Subject: A/84/21/DOC

I refer to Application A/84/21/DOC. I realise this is a Discharge of Conditions application upon which you would not normally invite public comments.

My comments upon **Condition No 23** – maintenance and management of sustainable drainage scheme (SuDS) are:-

Example Headwall Liner Sealing Detail
(Refer to ALP drawing no. A290-507 for details)

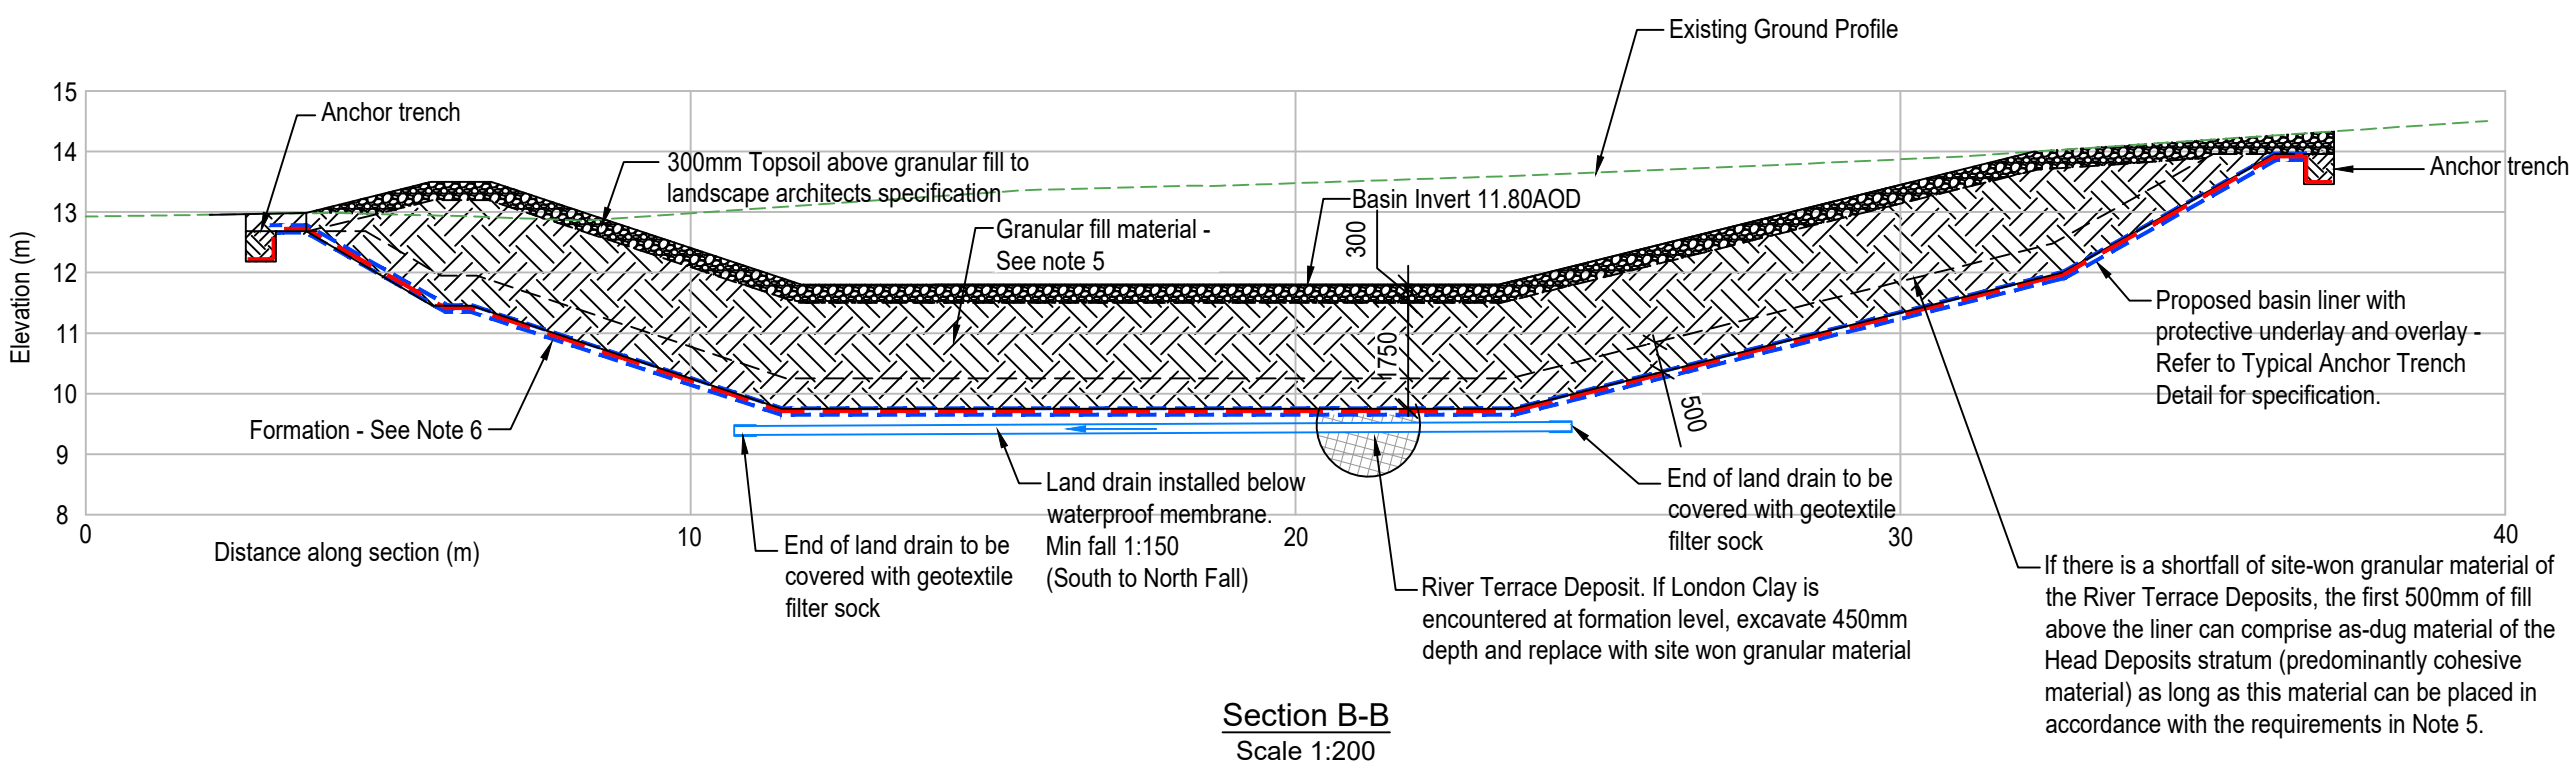
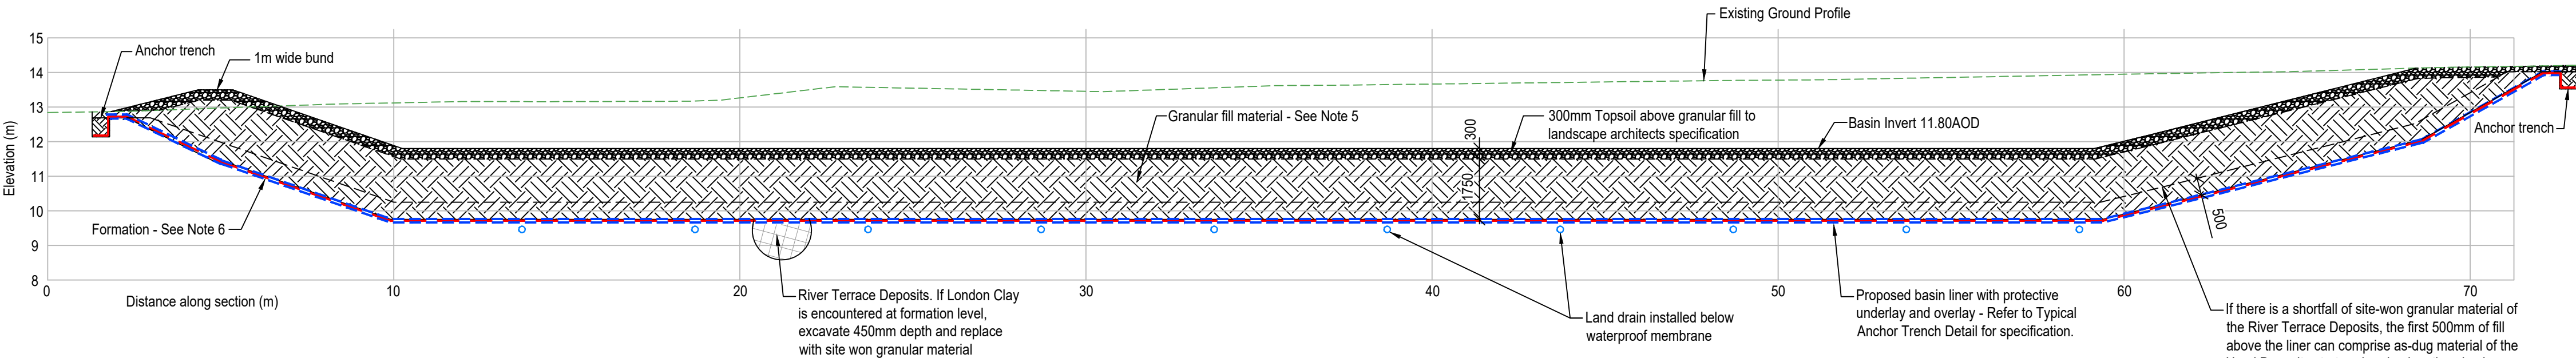
Lining ponds to resist flotation is always problematic. What seems to be proposed here is that the lining is at a level below that of the outlet and covered with granular (gravel and sand) material to resist flotation. Presumably, the lining will also retain water to the level of the outlet and thus the area could be unpleasant at times.
